WEST SUSSEX COUNTY COUNCIL CONSULTATION

TO:	Arun District Council FAO: Mr S Davis
FROM:	WSCC - Highways Authority
DATE:	21 November 2023
LOCATION:	Former Westside Supplies Unit West of 17 to 18 Durban Road Bognor Regis PO22 9QT
SUBJECT:	BR/267/21/PL Development of a new build four storey block of flats for 24 units (13 No 1 bed and 11 No 2 bed). This application is in CIL Zone 4 (Zero Rated) as flats.
DATE OF SITE VISIT:	n/a
RECOMMENDATION:	More Information
S106 CONTRIBUTION TOTAL:	n/a

drawing number: 2164(11)000 /
PROPOSED LOCATION PLAN
+ BLOCK PLAN

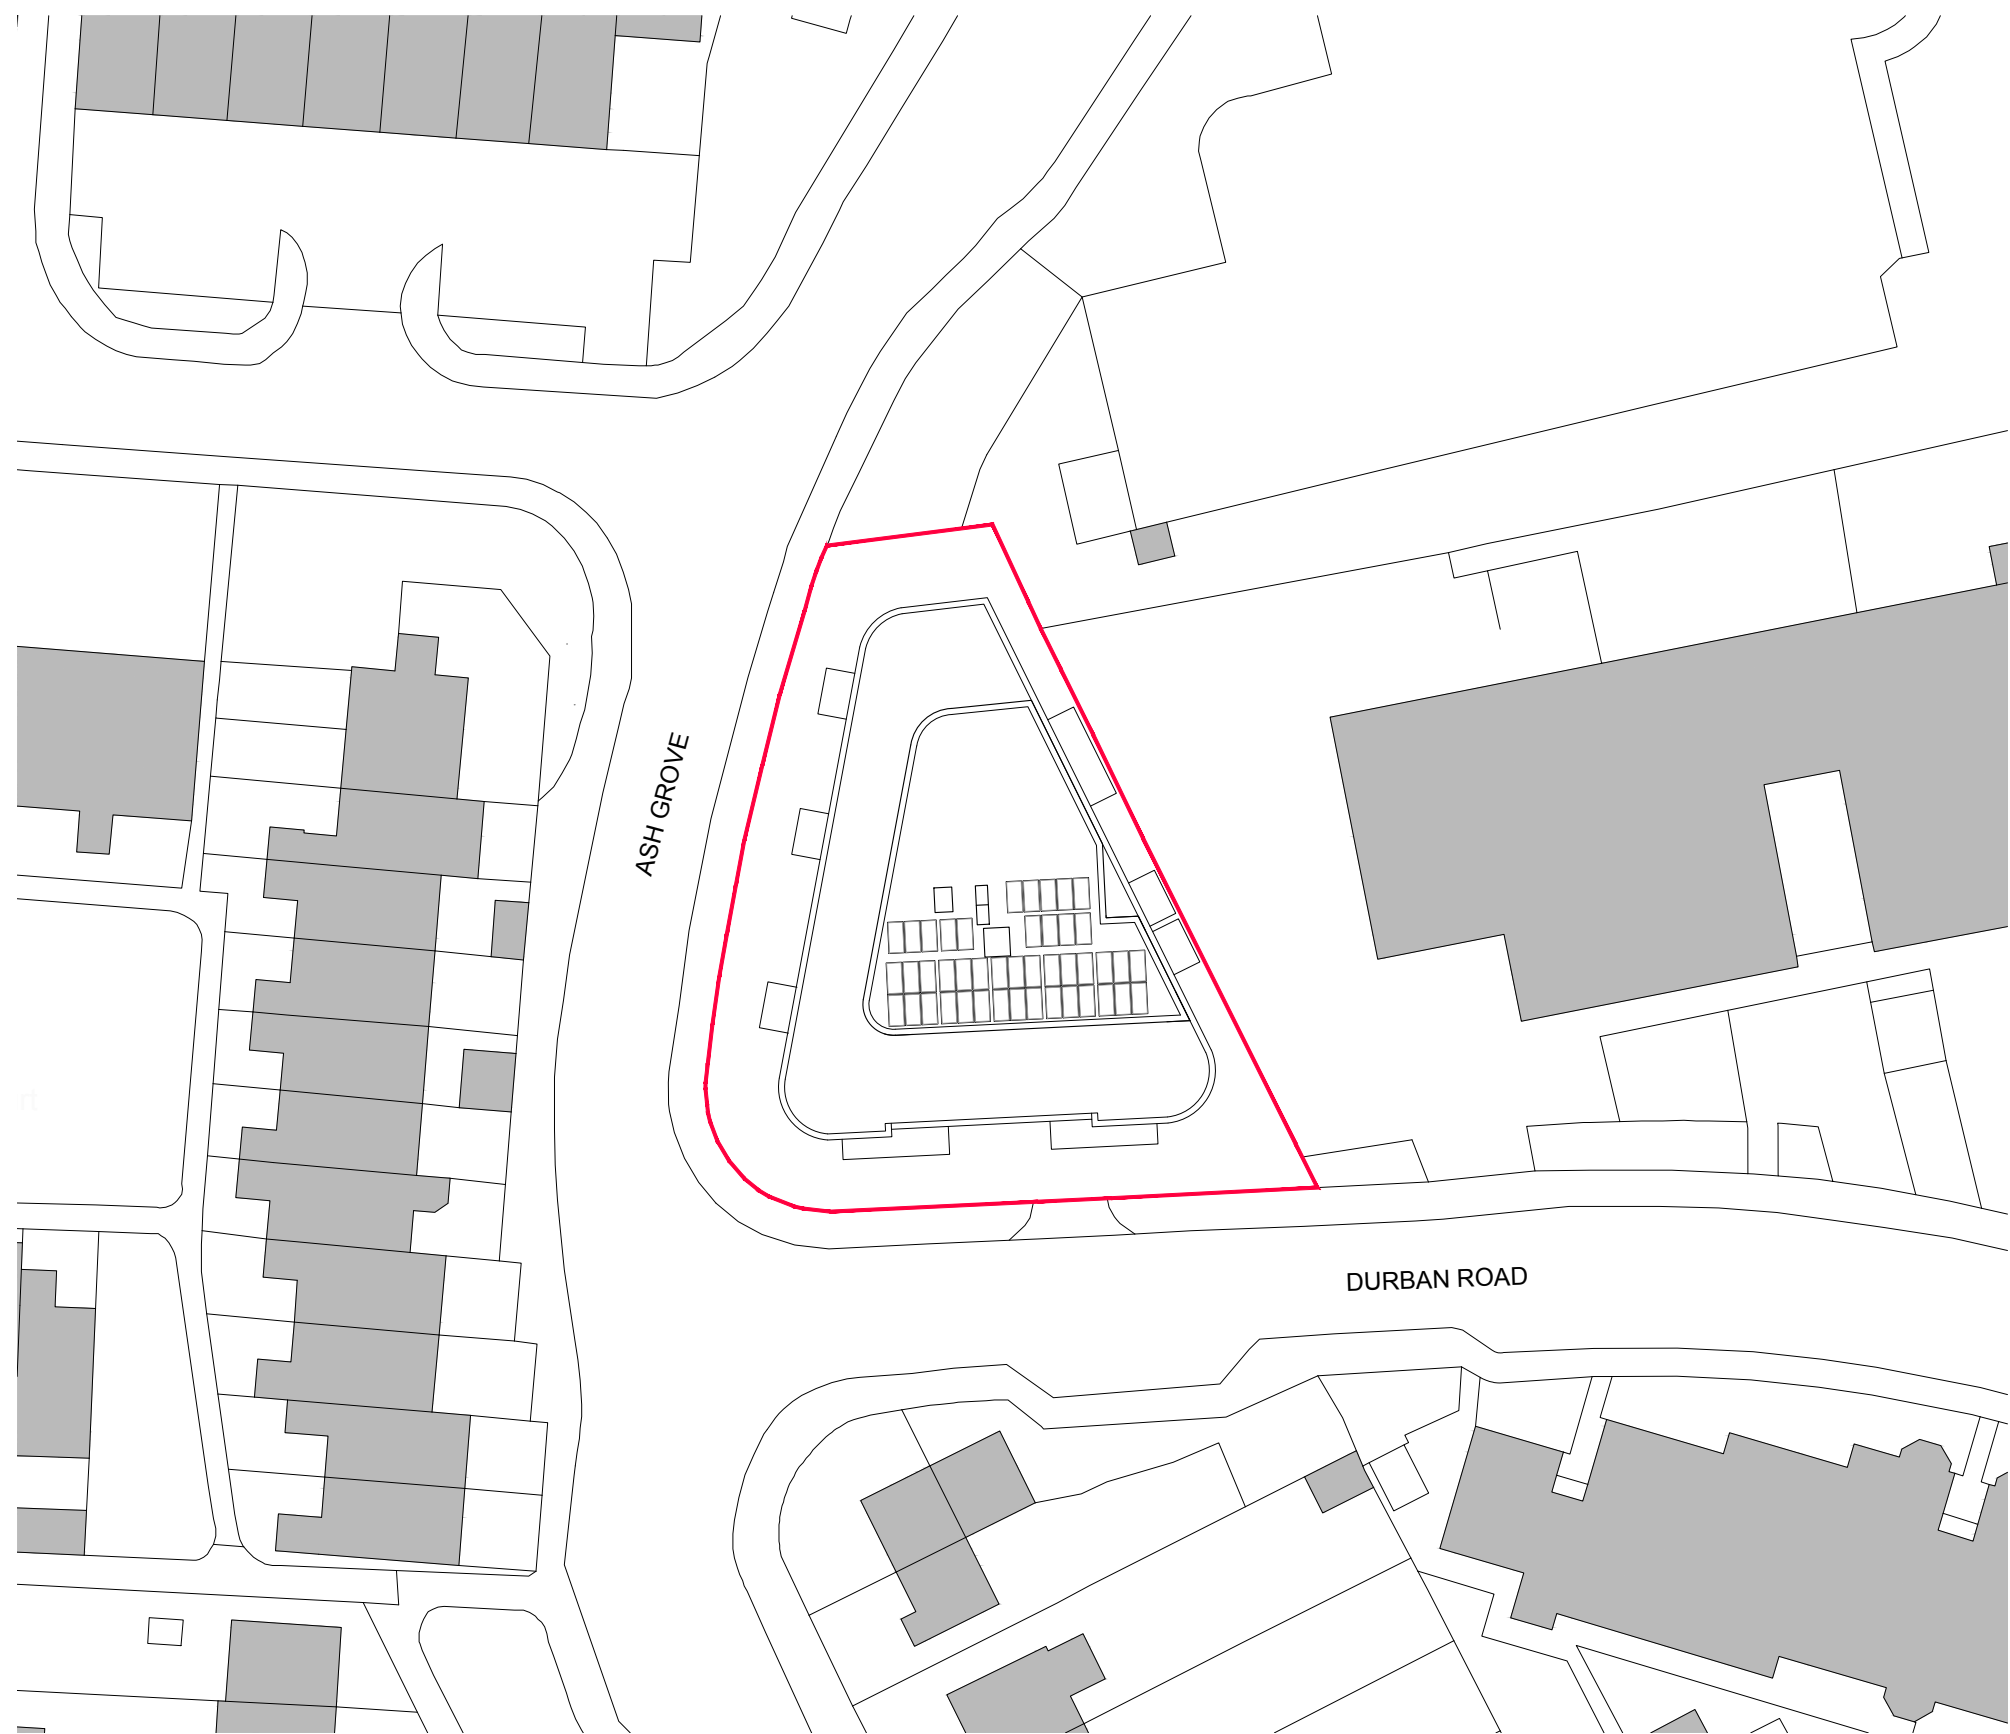
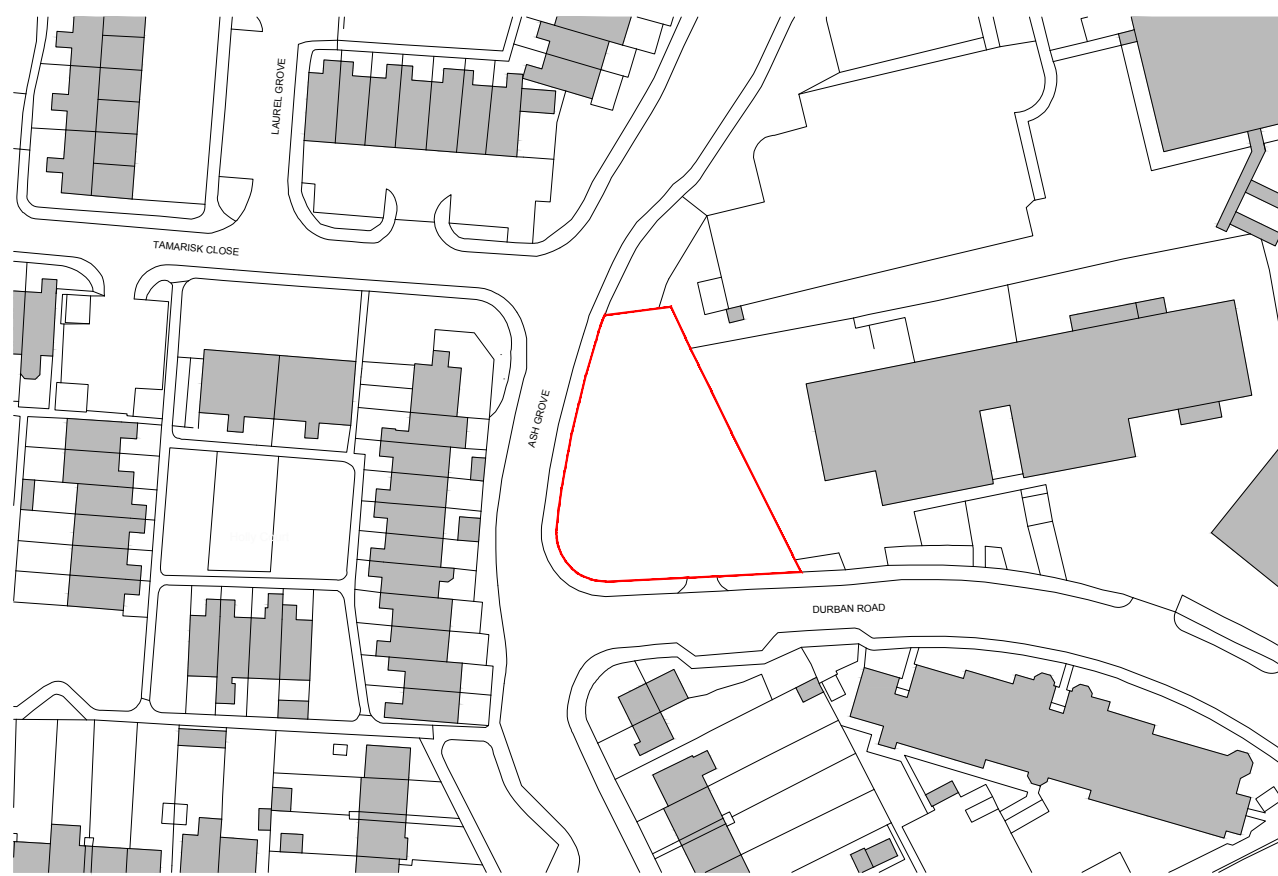
Visibility from this access onto Durban Road would appear to meet with Manual for Streets (MfS) parameters (43m from a 2.4m setback); however, the site is open plan and visibility cuts across the site. Due to the open plan nature visibility exceeds 43metres, consequently the enclosure of the land would result in a lesser visibility splay than exists presently. The LHA would like to see a plan

demonstrating the visibility splays. This plan can then be conditioned in order to keep these splays clear of obstructions. It is also apparent that some on street parking occurs on Durban Road, which may obstruct visibility for vehicles leaving the site; this should be looked at as part of a recent RSA.

The LHA would require an up-to-date stage 1 RSA to be carried out, signed, and dated to include all plans referred to. A Designers Response (signed and dated) must also be provided in editable format such as Microsoft Word for the LHA to enter their comments. Also, plans to clearly show the visibility splays onto Durban Road from the site access and at the junction of Durban Road/ Ash Grove must be submitted. These should also include the boundary treatments to demonstrate that these splays will not be obstructed. Please re-consult once the required information has been provided.
